Permit questions-University of New England, Stevens Avenue Armory3 messages

This email is to follow up on our conversation regarding your plan review questions on the Stevens Avenue armory for the University of New England. My notes indicated that you had two questions that focused on the Pre-function room. Below is a summary of that conversation as documentation.

DWG. **G-103**

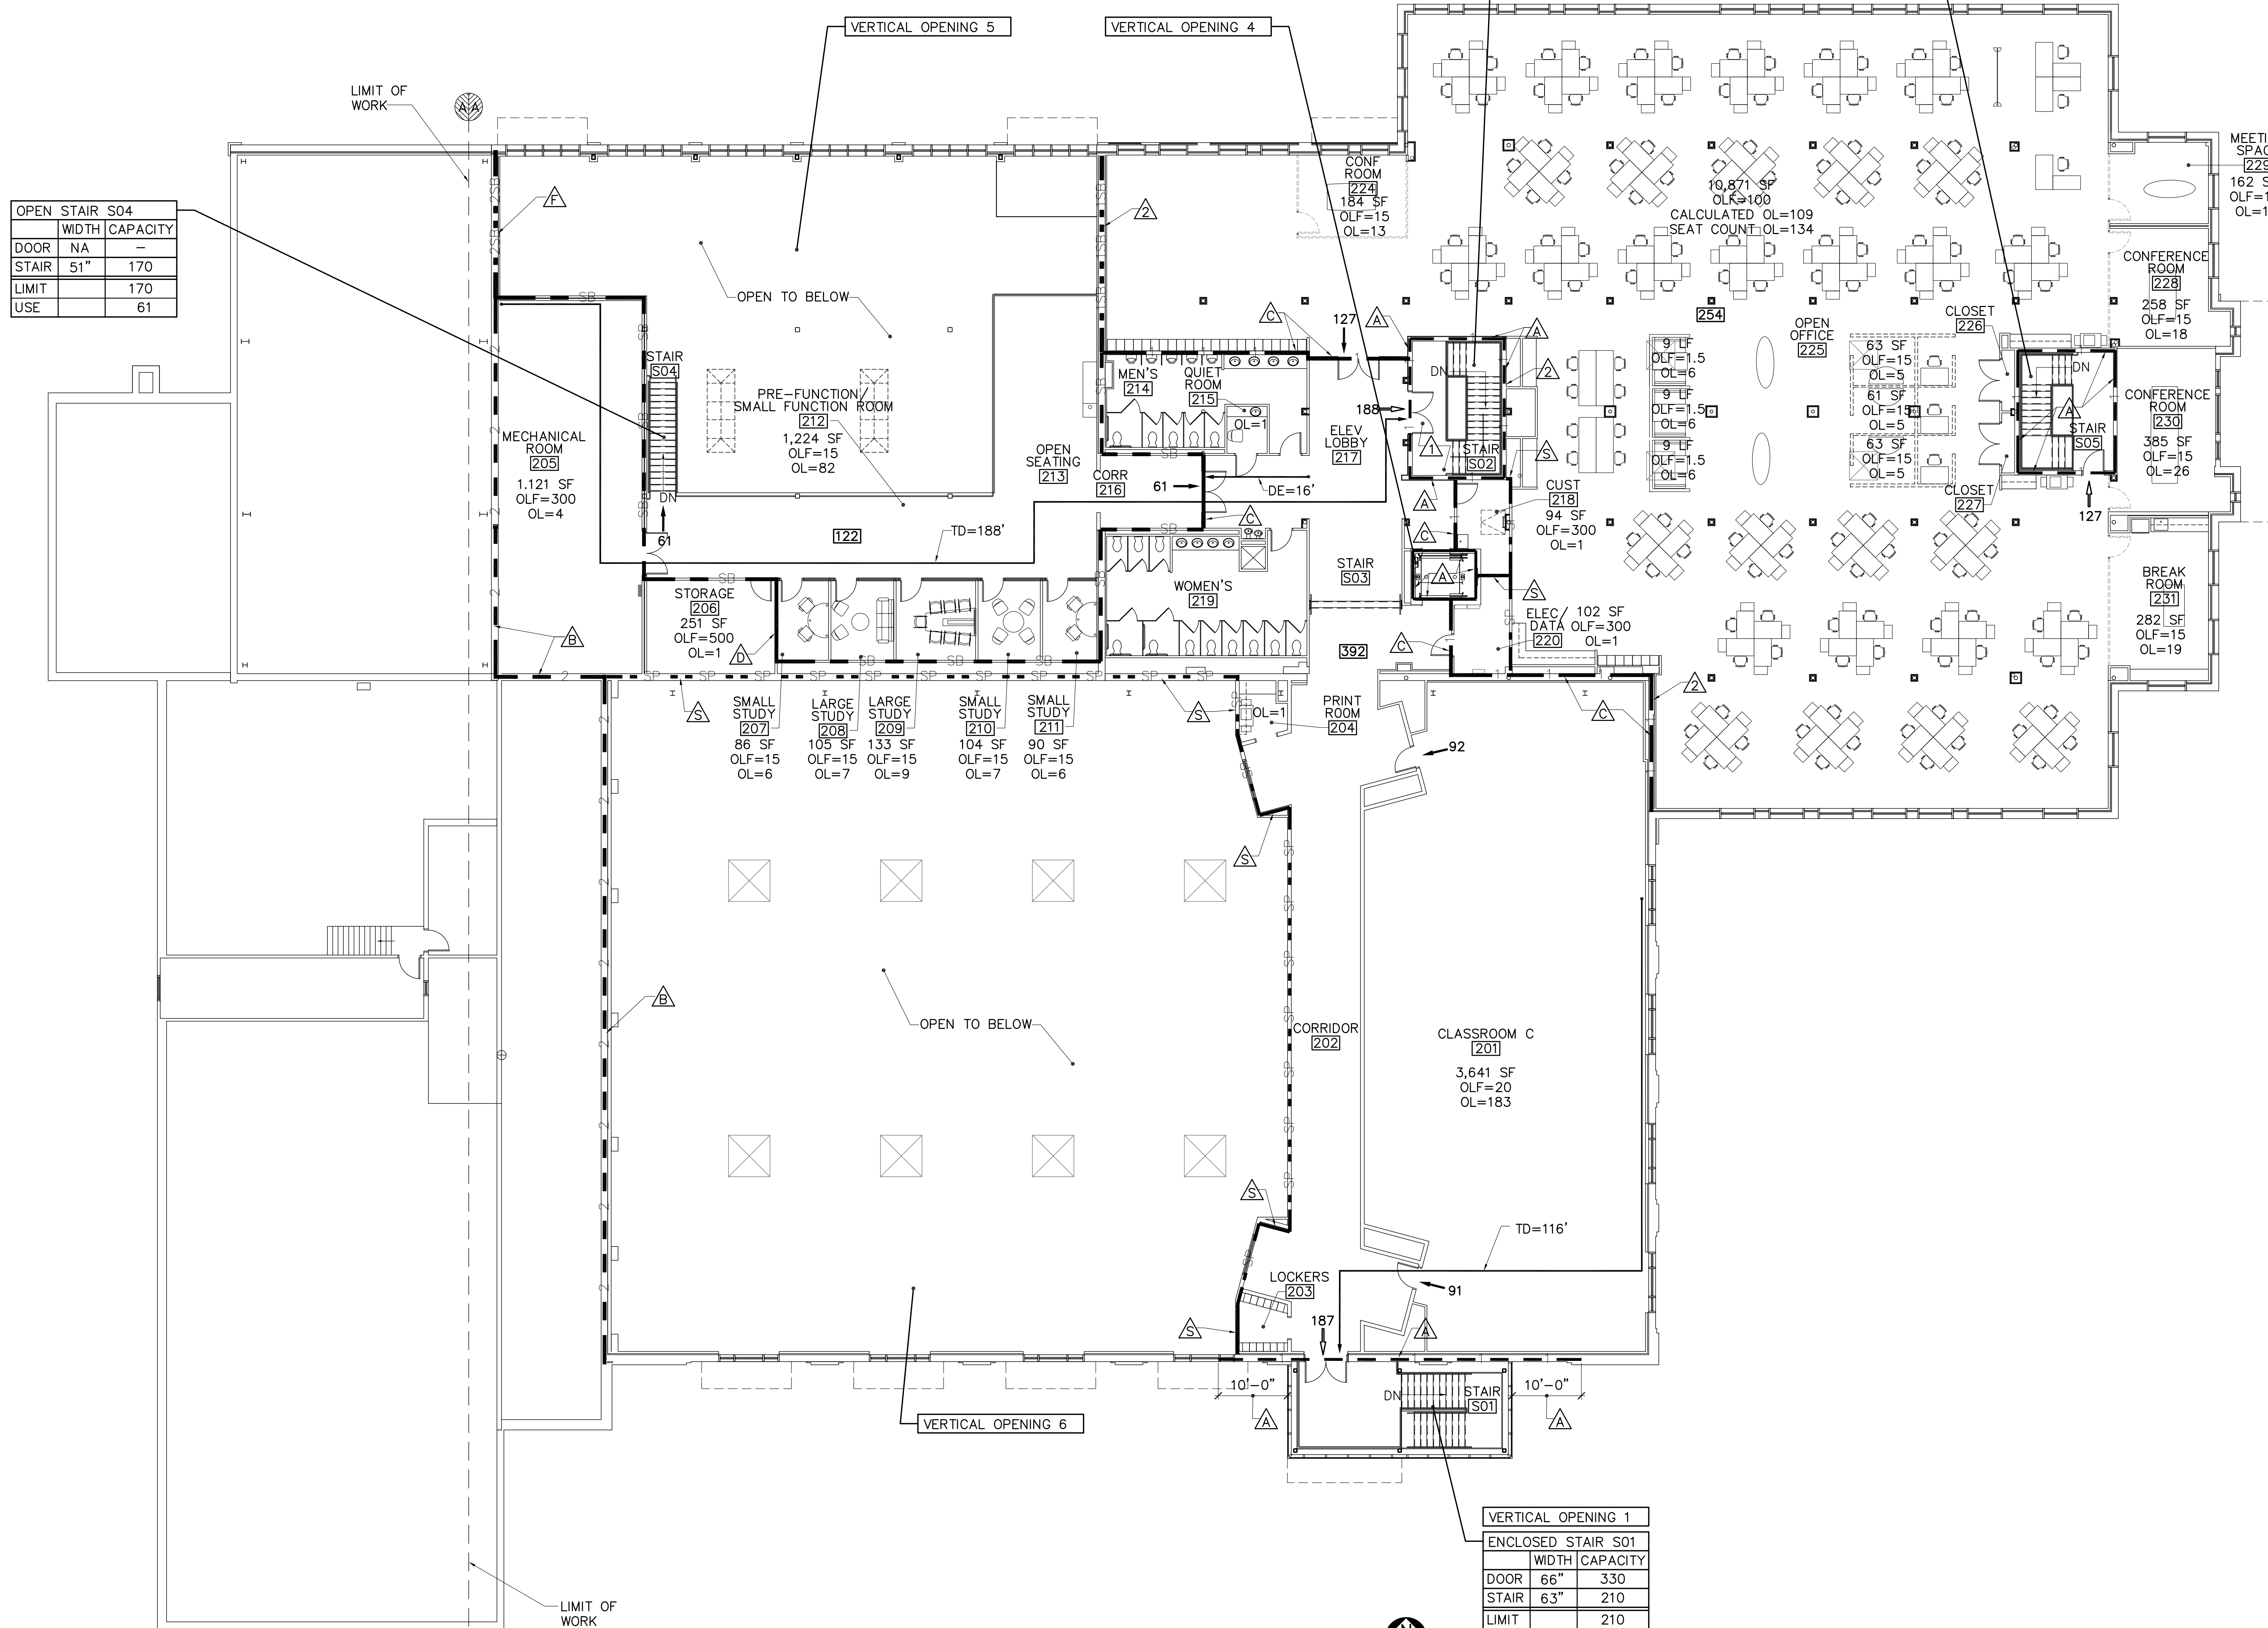
1. Regarding Vertical Opening #5 in the pre-function room, 116. Additional smoke detection has been provided within the small study rooms located on the second floor to provide advanced notification to building occupants. In addition, beam detectors have been provided at the roof level. These detectors are shown on sheet FA103, sheet 168 of 169.
2. Potential obstruction of the second floor egress pathway. As discussed, the planned furniture will be sofas and soft seating located in front of the gas fireplace. No furniture is planned along the egress path in front of the small study rooms.
